Engineers Comments Regarding Surface Water Drainage

Application Reference:	CM/6/24/DOC	Reviewer Reference:	ADC/EXT12/GK
Planning Officer:	Jessica Riches	Date of Review:	01.10.2024
Site Name:	Land to the West of Church Lane and South of Horsemere Green Lane Climping		
Application Description:	Approval of details reserved by condition imposed under CM/1/17/OUT relating to conditions 6-Phasing Plan and Programme , 8-Arboreal Method Statement, 9-surface water drainage scheme, 10-discharge of flows to watercourses or the culverting, diversion, infilling or obstruction of any watercourses on site , 11-Flood Management and Mitigation scheme, 12-Ecology Management and Mitigation Plan, 13-archaeological works, 14-Constuction Method Statement, 15-Travel Plan, 16-energy efficiency measures, 17-acoustic barrier, 21-Employment and Skills Plan and 22-provision of broadband.		
Assessment Number:	2 of 2

NoApplication Reference: CM/6/24/DOC	Initial Issue Date:
Site Name: Land to the West of Church Lane and South of Horsemere Green Lane Climping	Issue Date: 02/01/2024
	Reviewer Reference: ADC/EXT12/GK

Headwall Sections - Basin 2

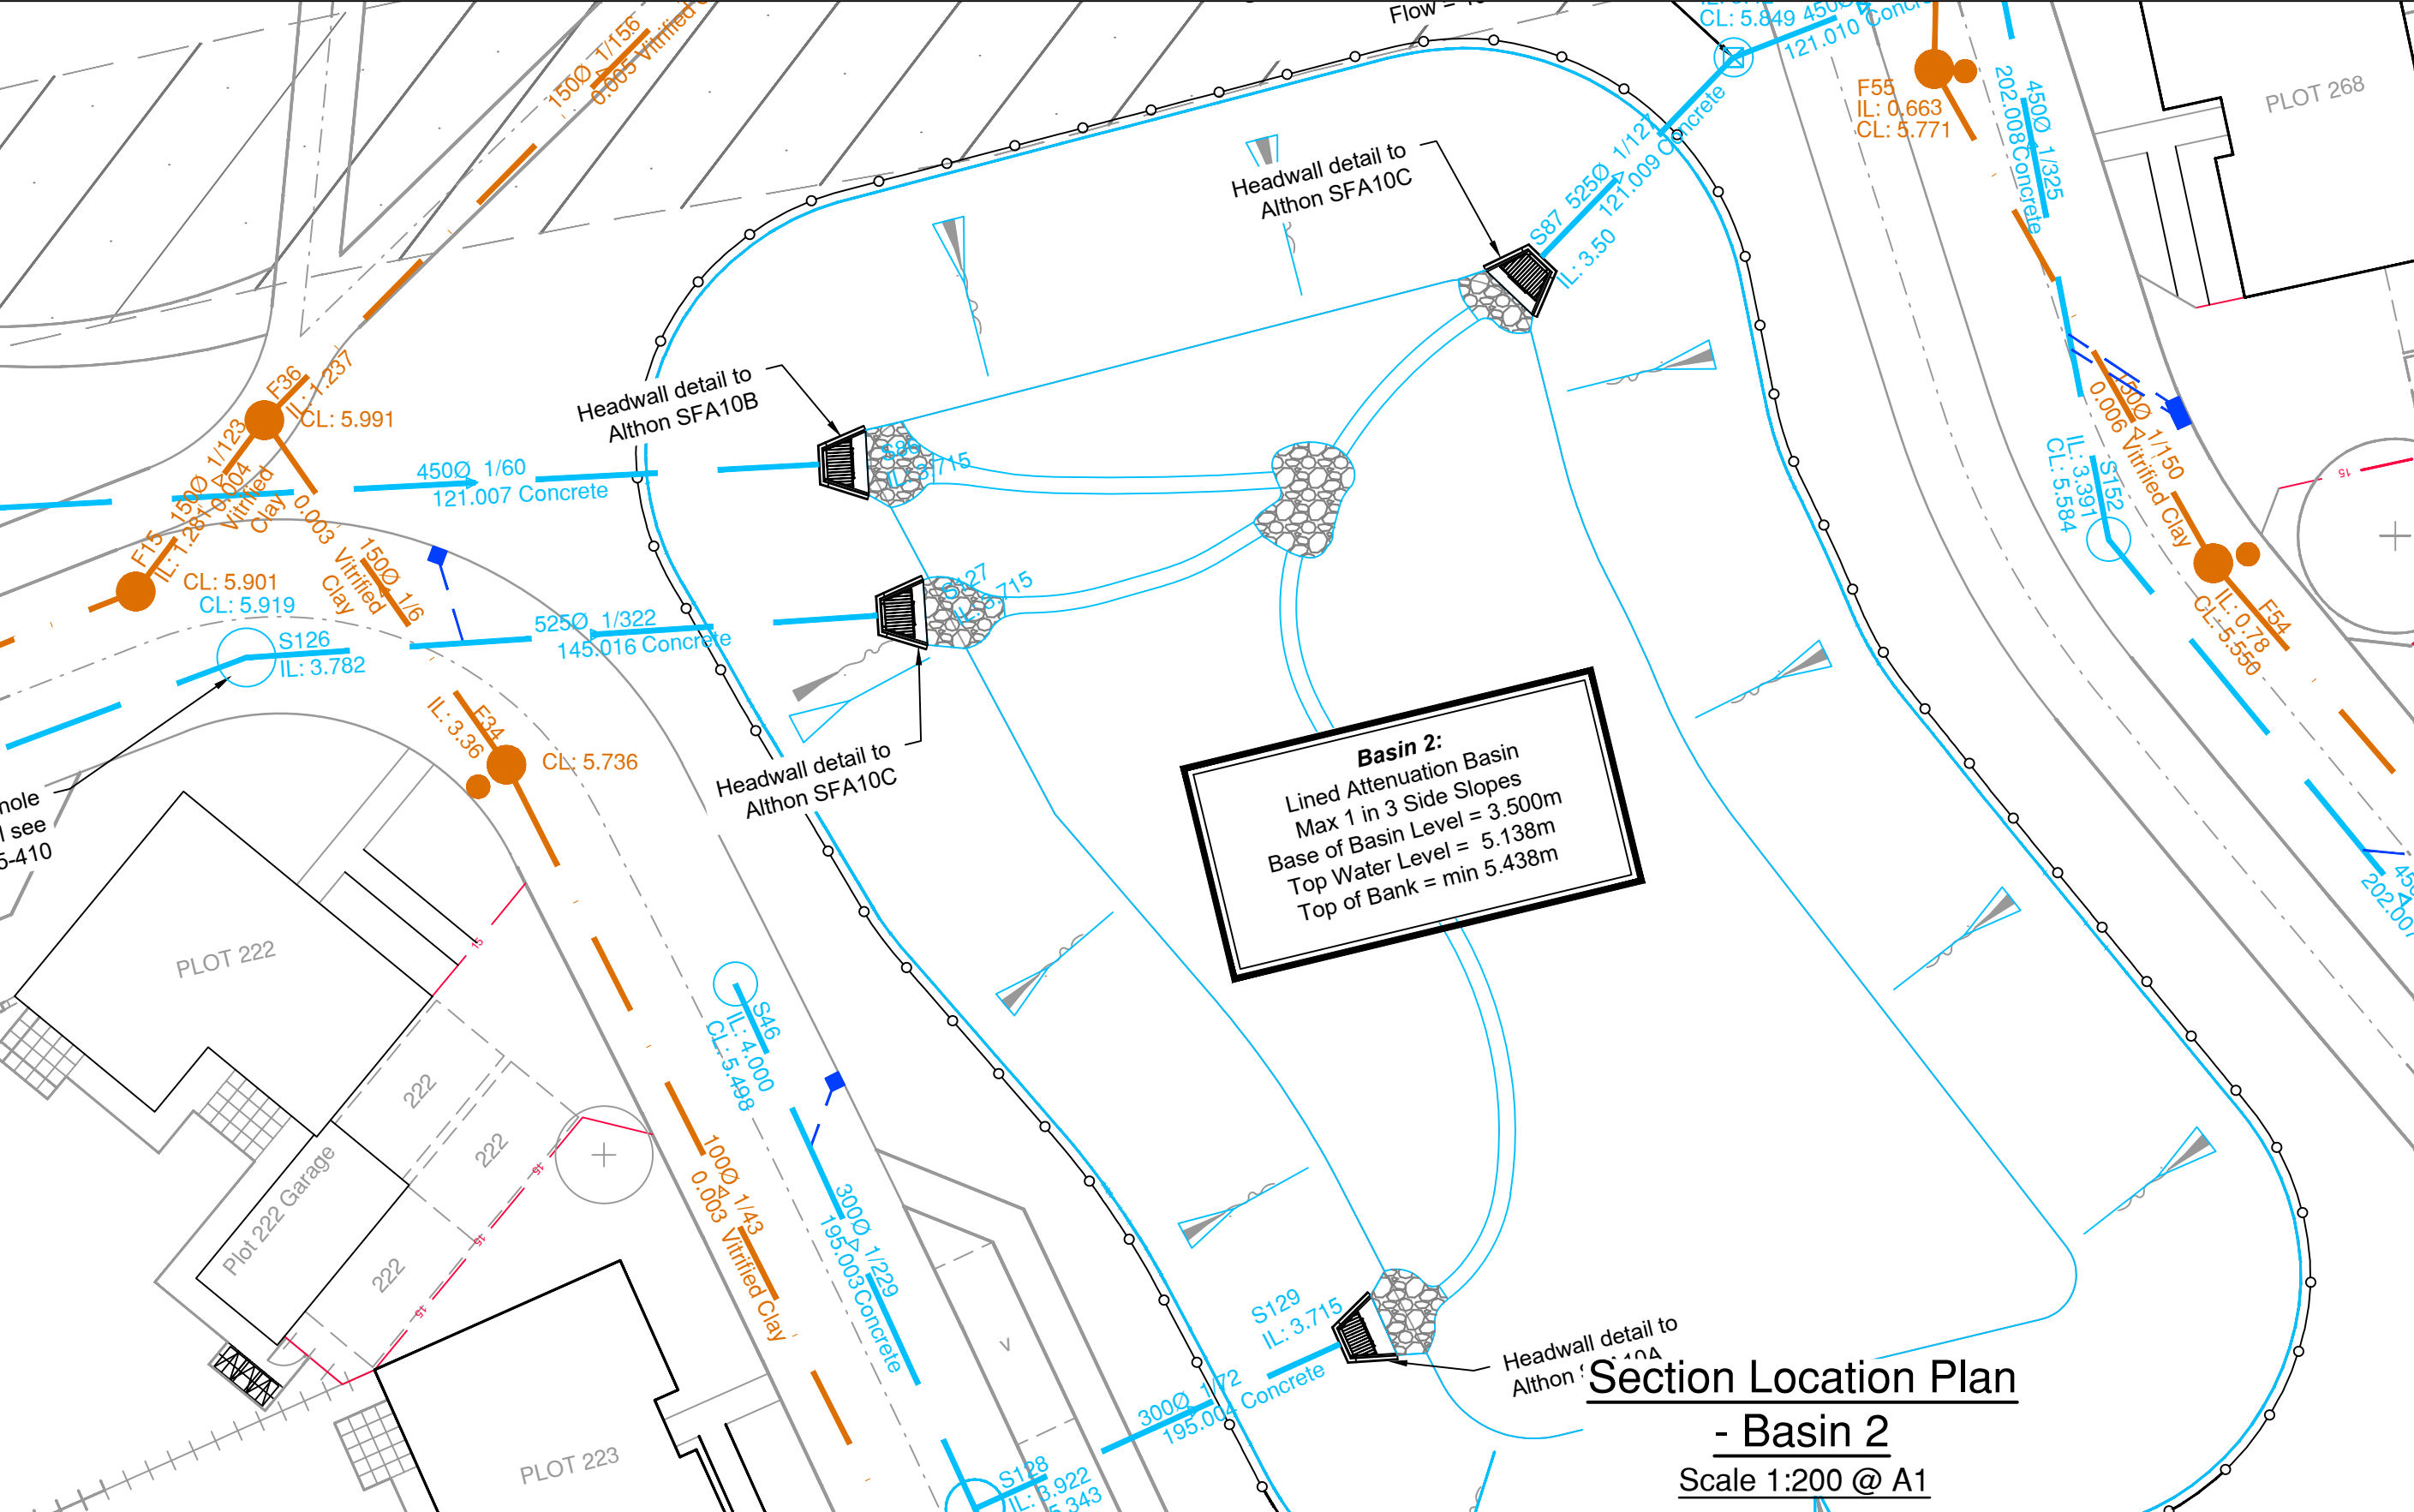
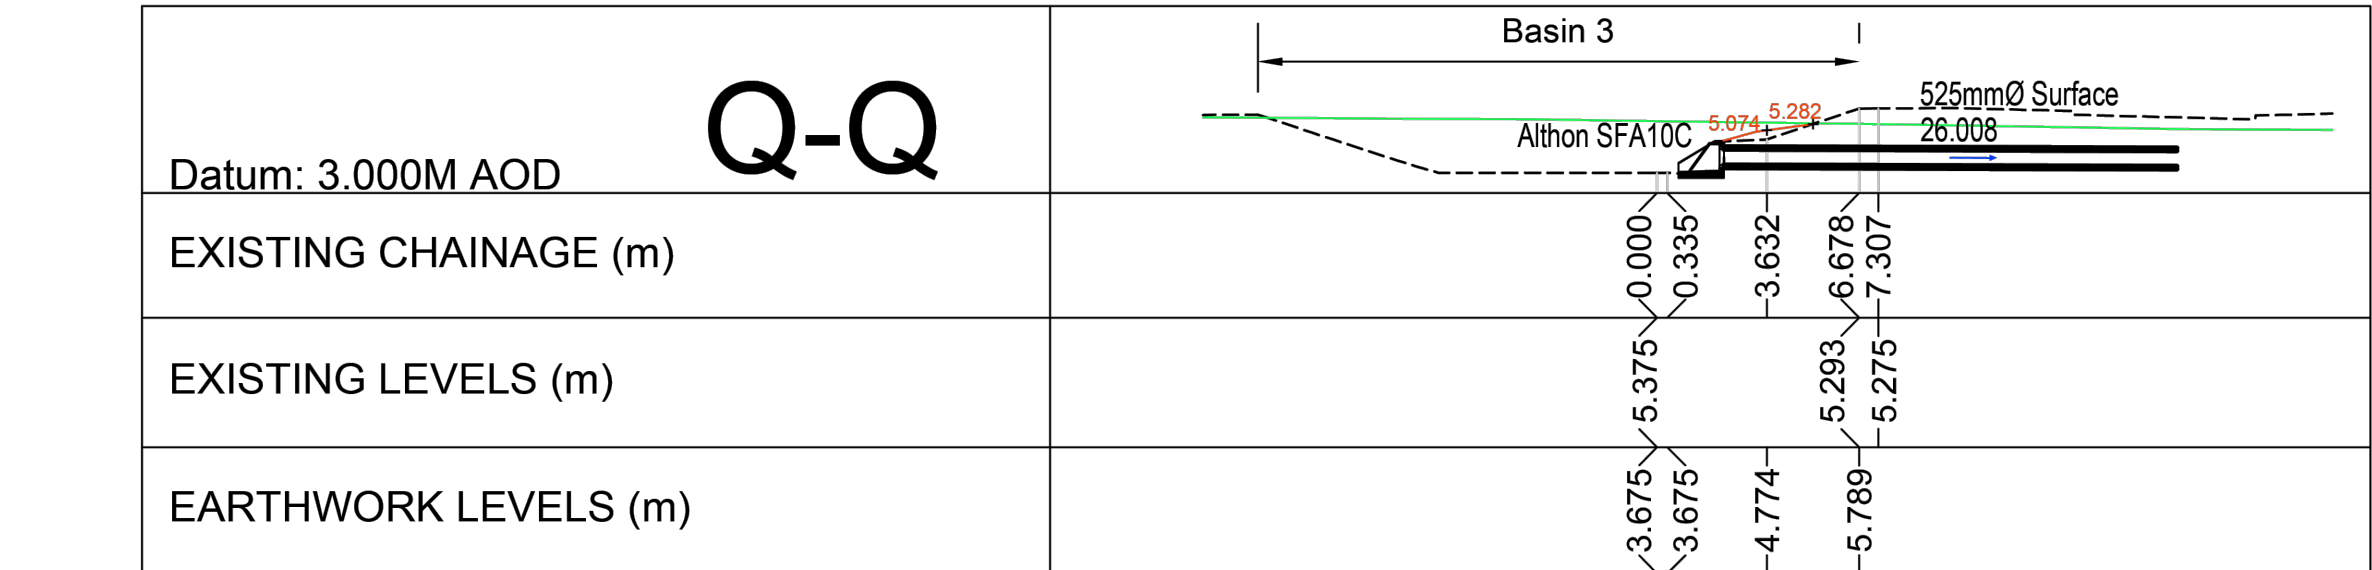
11.	No drainage details have been provided, all materials and structures are to have details provided including control devices.	No comments – refer to updated design.	Headwall details have been provided but they are generic. Each headwall should contain the outfall IL, the basin level, the pipe size and the earthworks details. There have been submitted typical details of the swale but detailed design details are required. Please provide detailed construction details for all the attenuation tanks. Also, include the road/footpath detail above where applicable.	Refer to headwall sections plans - FOR-E5139-482 to 485. Altho specific headwall details are shown on these plans. The sections shown on the plans give specific information for how the headwalls tie-in with surrounding earthworks and base of basins

16.	A new water course is proposed along the northern site boundary. Is this just a conveyance swale for the onsite system or does this receive flows from anywhere offsite? There is no mention of this in the FRA. It is noted that the side slopes are 1:2 these should be reduced to 1:3 as it is noted that the ‘swale’ is up to 1.9m deep in some places.	No comments – refer to updated design.	Comment remains.	This is a proposed swale for conveying flows from the proposed site. SI works done by G and W encountered groundwater at 1.5m bgl in the road south of the swale. The swale is proposed as a conveyancing feature and will not infiltrate into the ground. Swale banks shall be 1:3 with a granular sub-base. For the swale levels refer to FOR-E5139-492.
